Application for a non-material amendment following a grant of planning permission.

ERECTOR OF SEVEN INDUSTRIAL UNITS AND ASSOCIATED WORKS

H02-0440-09

CHANGE OF SURFACE MATERIAL IN STORAGE AREAS FROM TARMAC TO CONCRETE.

Date Apr 2010
Scale 1:250 @ A3
Dwg. no. P391 - P05

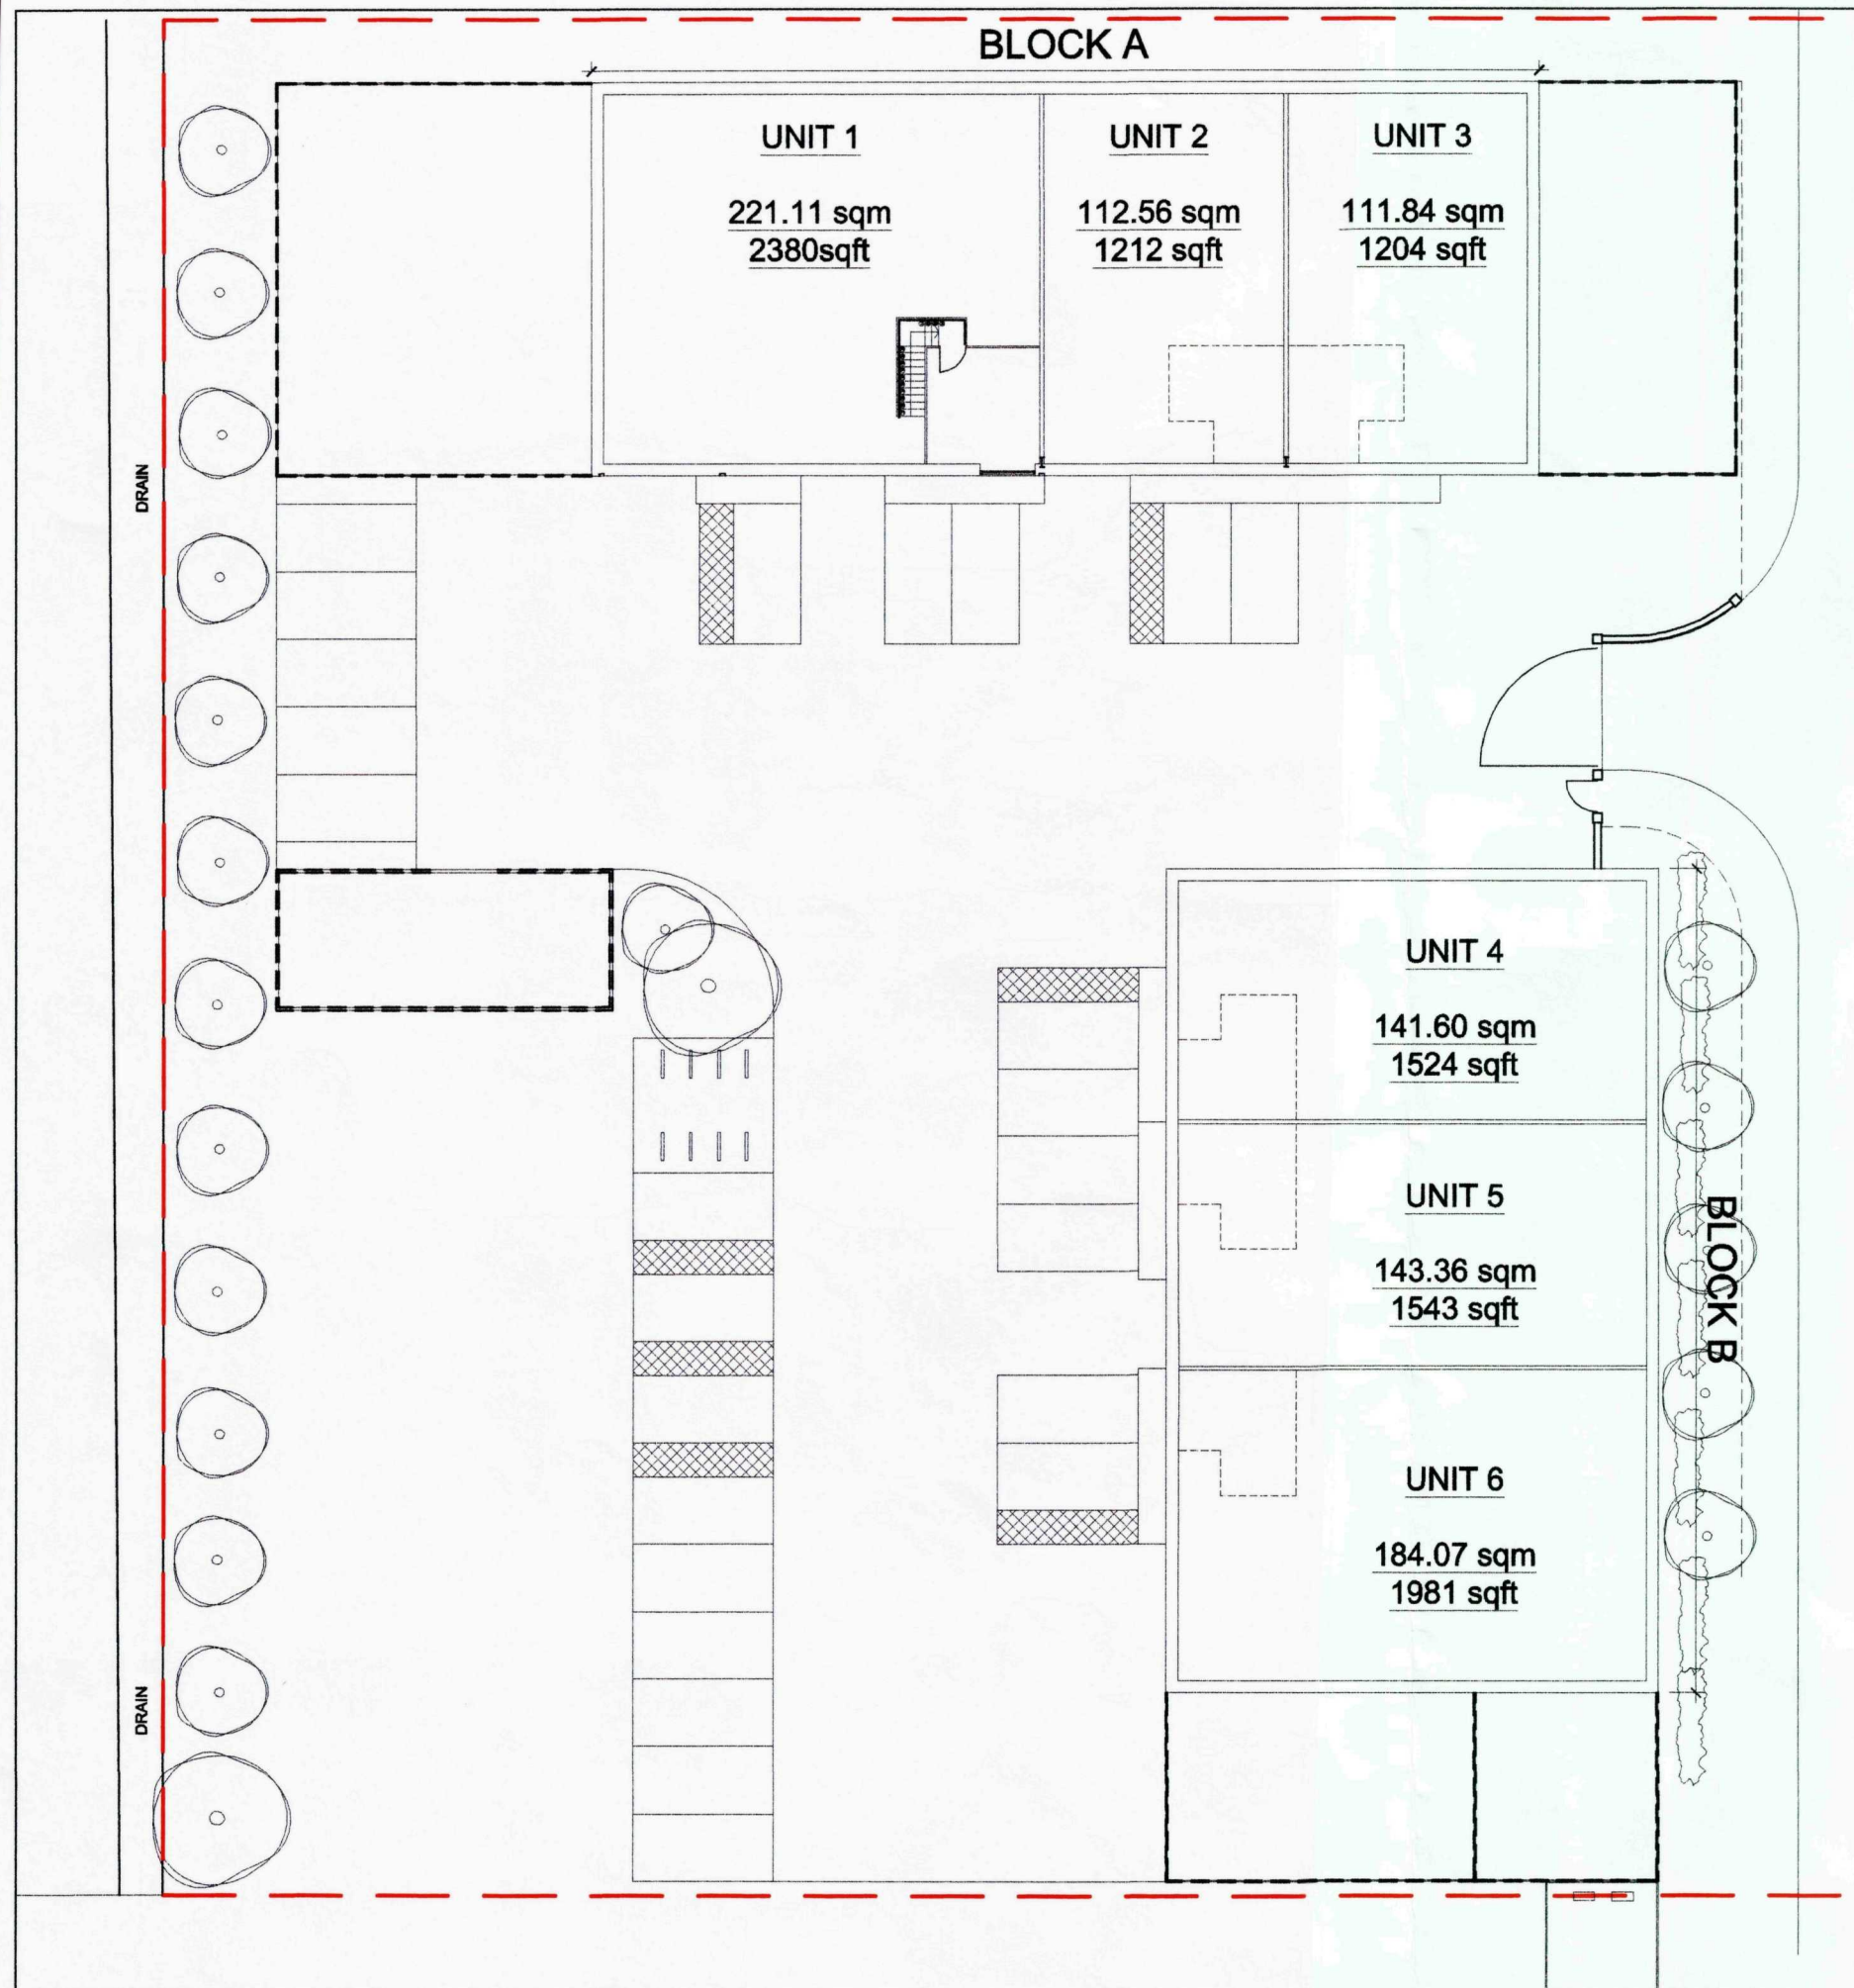
WINDOW TO BE ADDED INTO UNIT 1 AT NEW FIRST FLOOR LEVEL, TO SERVE NEW FIRST FLOOR OFFICE SPACE.
